Our Ref: PEF/SD/28854  
Your Ref: Y/21/18/DOC

Drainage  
Land at Kings Close, Yapton

PROJECT
Standard Detail
High Storage Soakaway

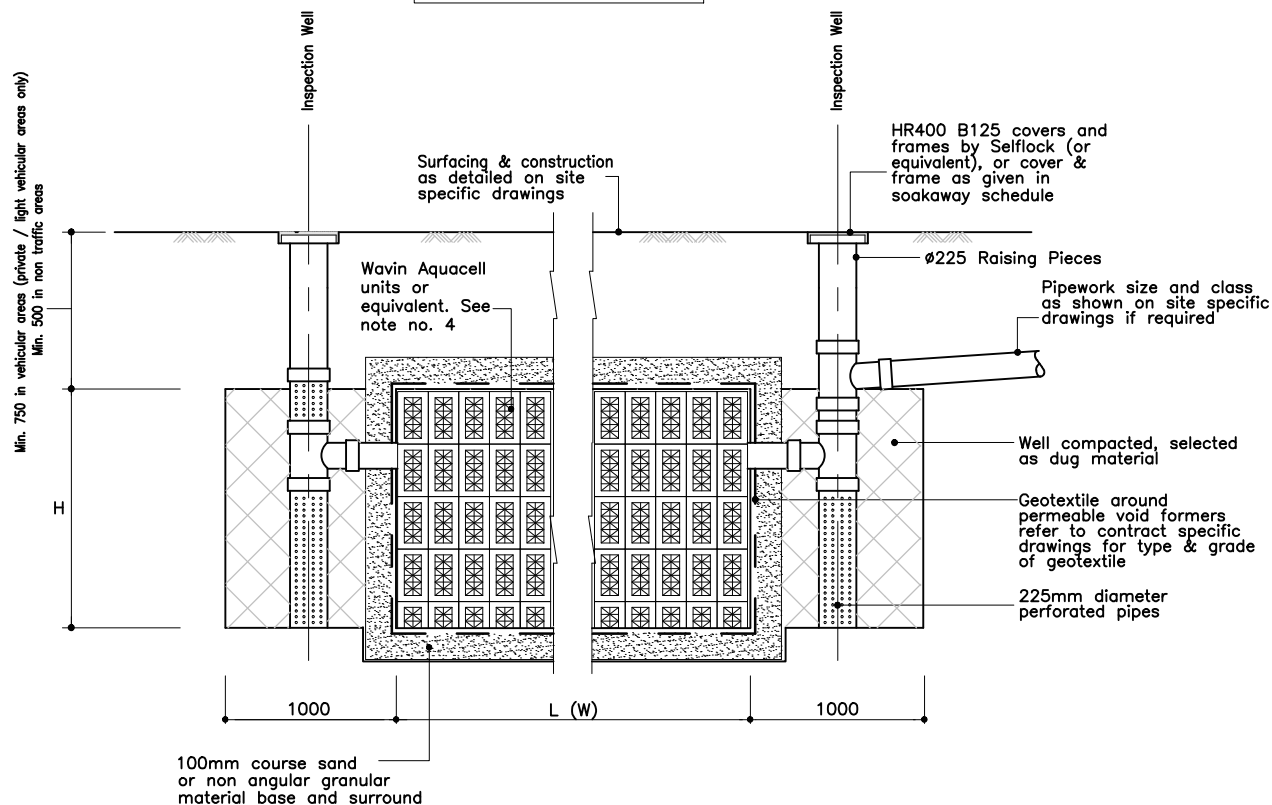
- 1) As shown on the soakaway schedule and standard detail, soakaways type SA 'A' have a total depth of 1.7m and an effective depth (H) of 1.2m. The calculated water depth of 1.13m is served by the 1.2m deep high storage soakaway.
- 2) As shown on the soakaway schedule and standard detail, soakaways type SA 'B' have a total depth of 1.7m and an effective depth (H) of 1.2m. The calculated water depth of 1.04m is served by the 1.2m deep high storage soakaway.
- 3) As shown on the soakaway schedule and standard detail, soakaways type SA 'C' have a total depth of 1.7m and an effective depth (H) of 1.2m. The calculated water depth of 1.12m is served by the 1.2m deep high storage soakaway.
- 4) Table 4.6 of Ciria Report 156 does indicate that a safety factor of 1.5 can be used for hydraulic design.
- 5) Drawings for soakaways, manholes and catchpits can be found herewith.
